Two storey rear extension, porch to front and conversion of roof space with two front dormers

Fidra Yapton Road Middleton-On-Sea

Thank you for your internet representation made on 9th April 2019 which has been recorded as '**an objection**' with the comments as follows:

DWG. No. 1901191/PL/2A

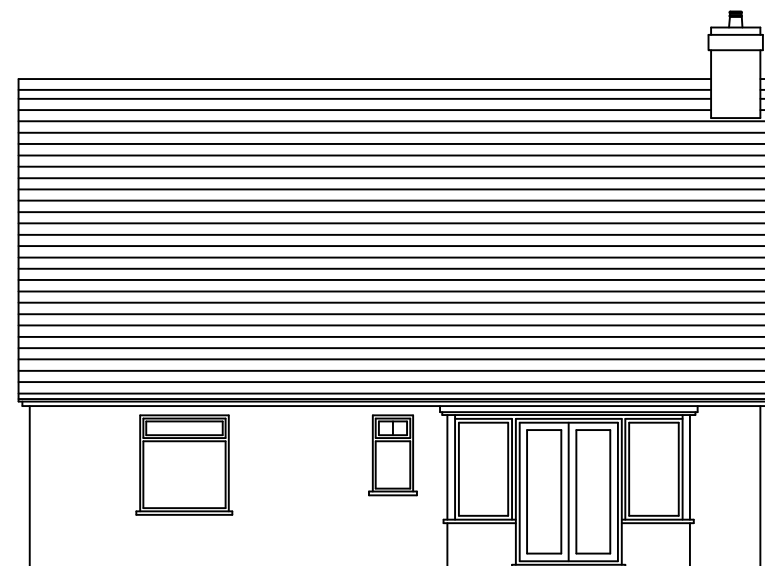
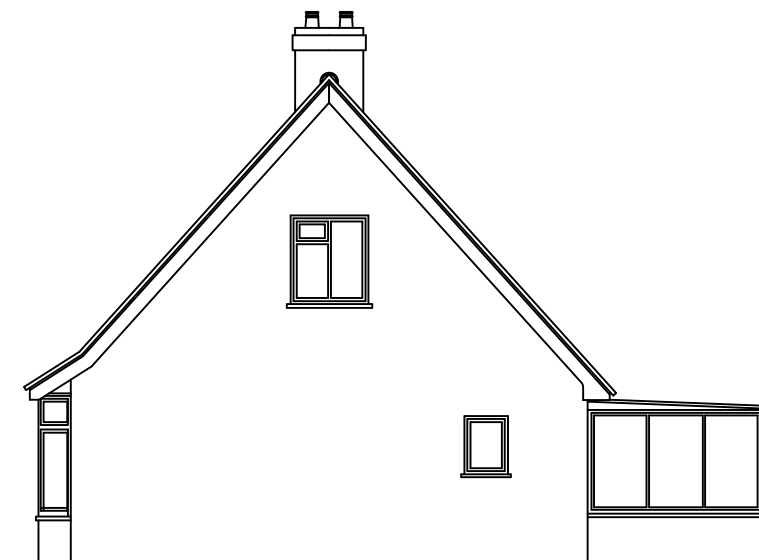
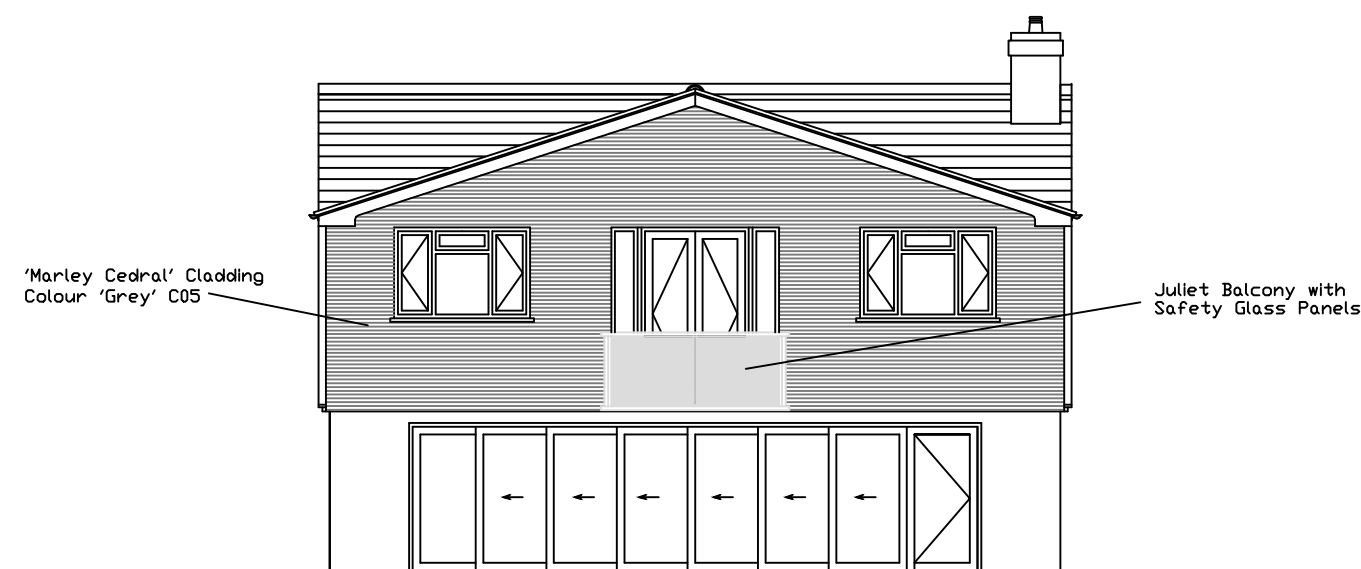
We live in Middleton House adjacent to the site, and have done an extension being very careful to not overlook any neighbours house or garden and bought the house due to the privacy of not being overlooked. I am not happy with the new windows on the plan overlooking our private garden and house. We have installed a hot tub in the end of the garden which we use most days and walk to and from our house naked and our middle floor south facing bedroom windows of our teenage daughters would now be able to see in from the proposed development. Neither of which would be appropriate.
